Development Control
Ribble Valley Borough Council

Application no: 2026/0135

Address: Former Household Waste Recycling Centre off Whalley Road Langho BB6 8AB

Proposal: Regularisation of use of land for open air storage of vehicles (within use Class B8), provision of welfare unit and jet wash.

SHEET: Proposed Site Plan

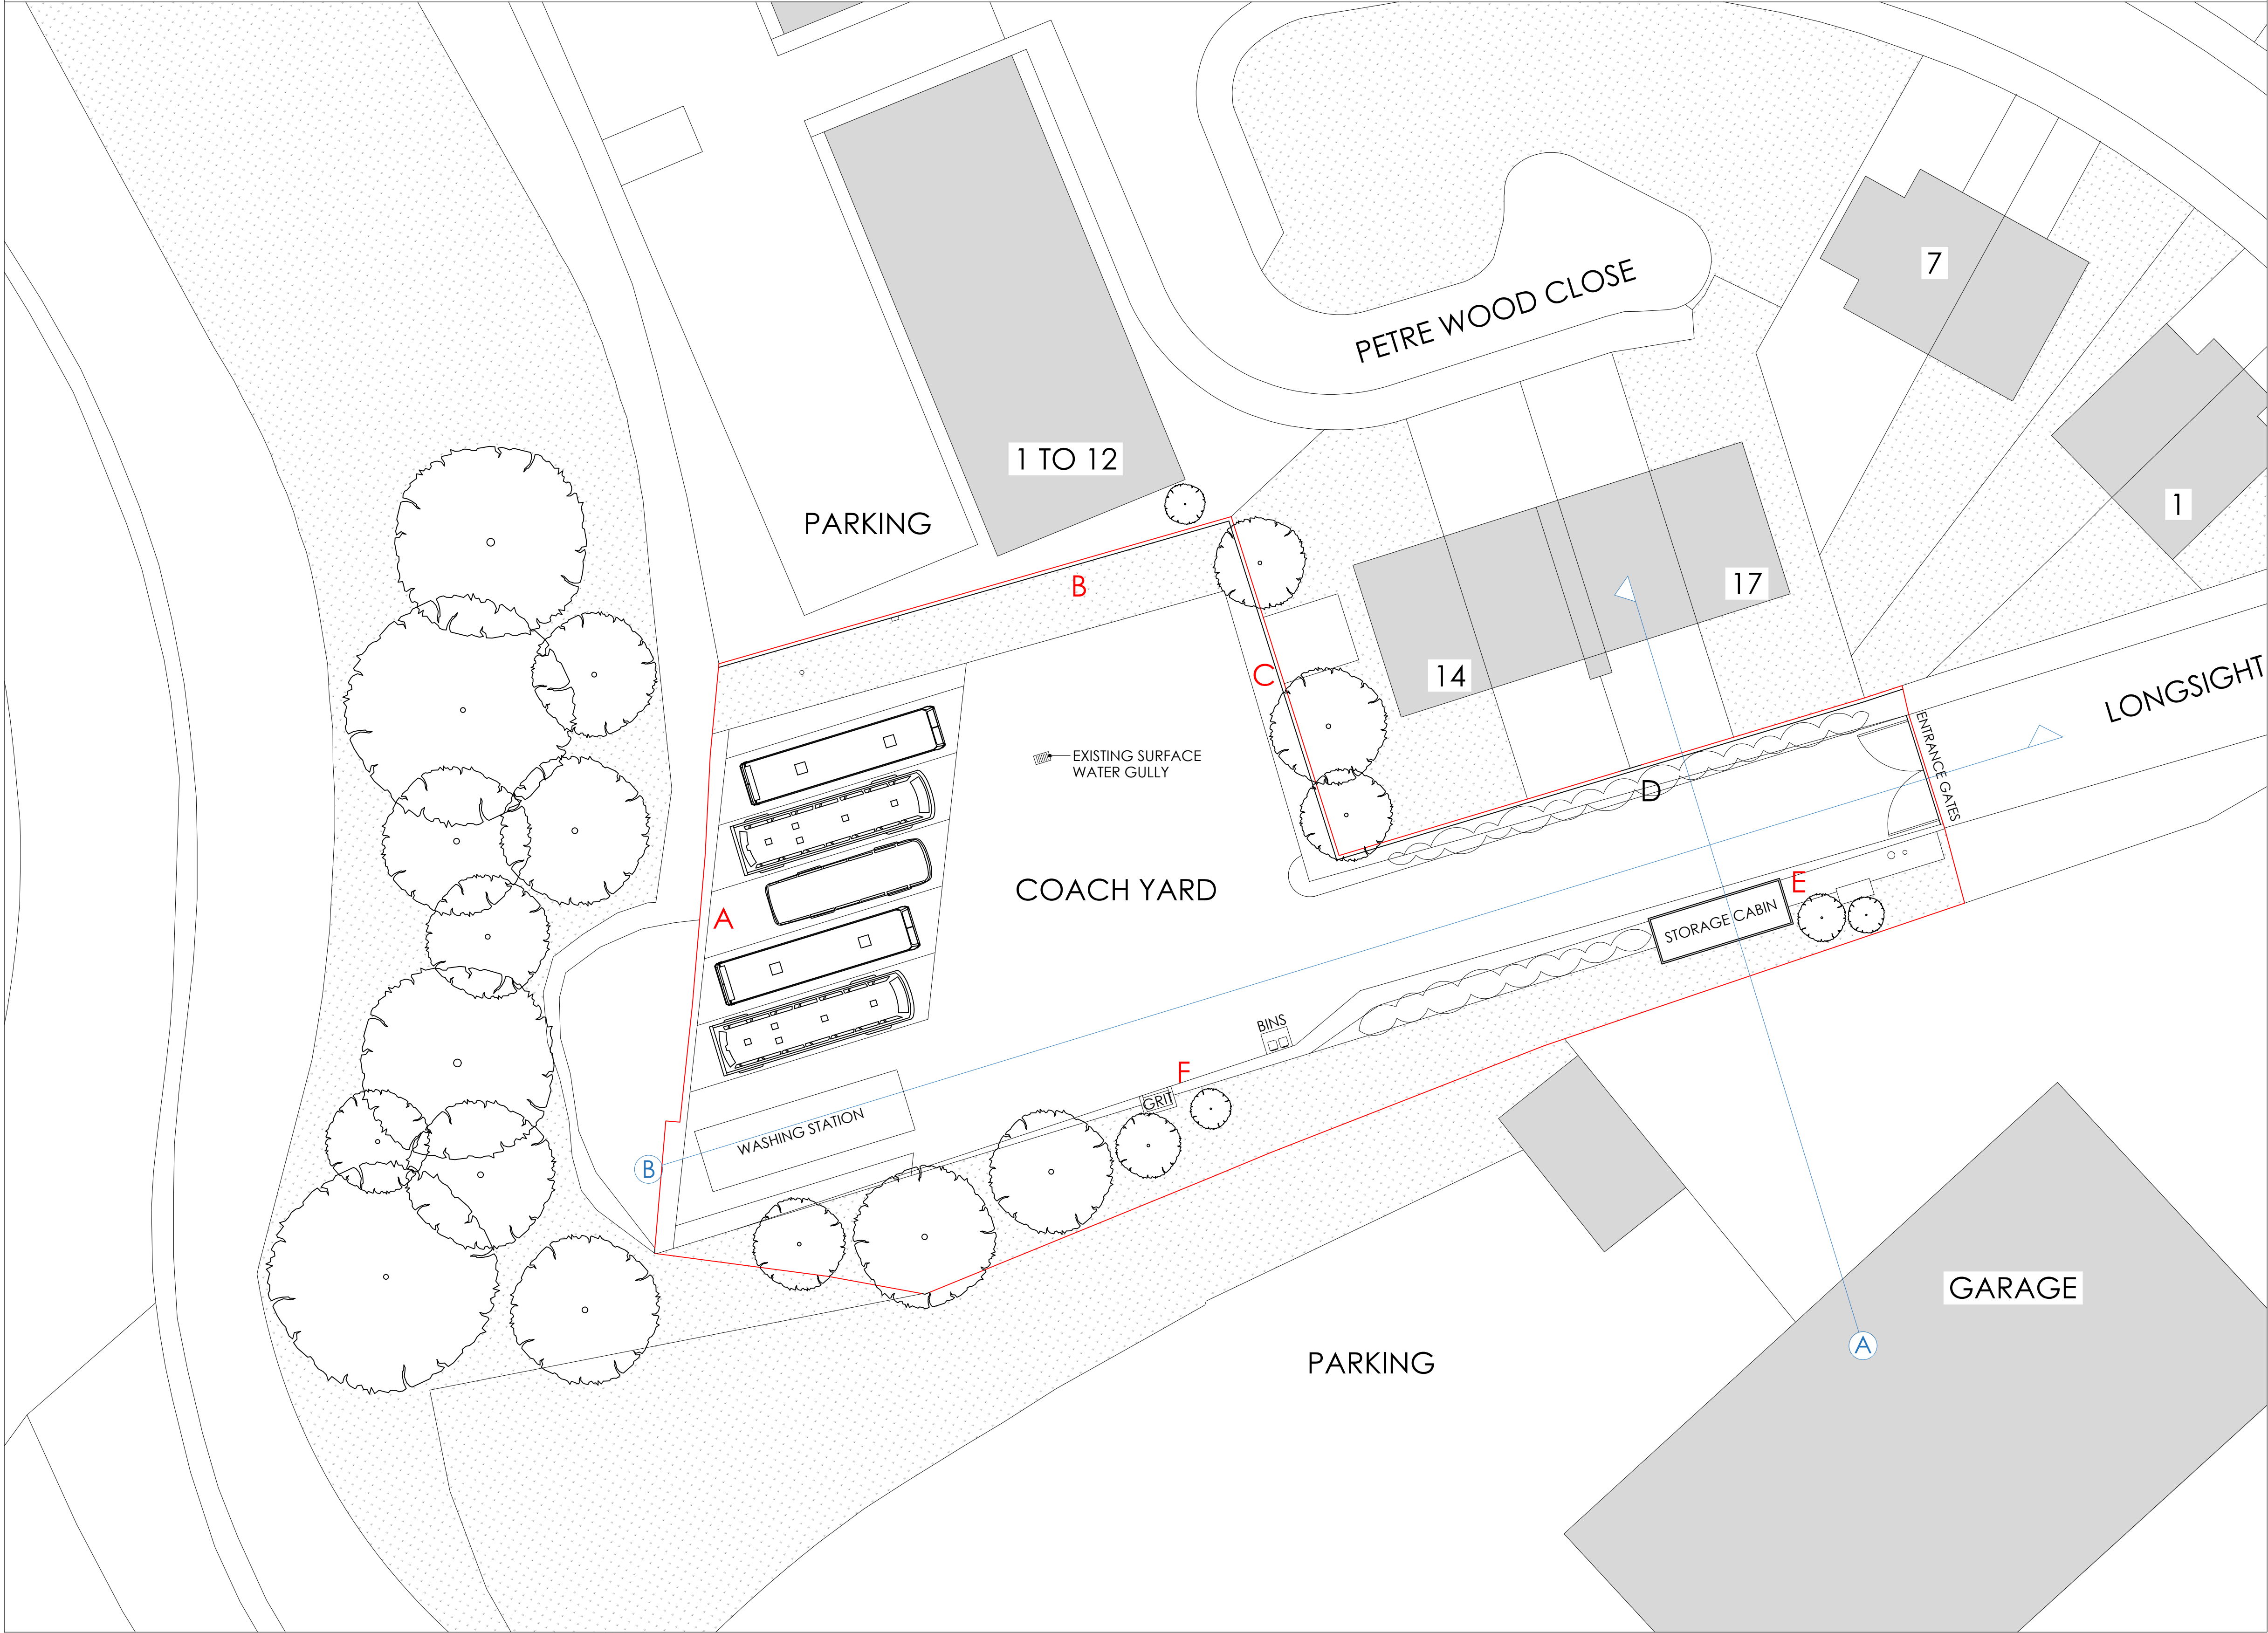
a) Car wash.

All the surface water drainage from the car wash, parking and hard standing areas shall be passed through an oil interceptor designed and constructed to have a capacity and details compatible with the site and the means of discharge from the site.
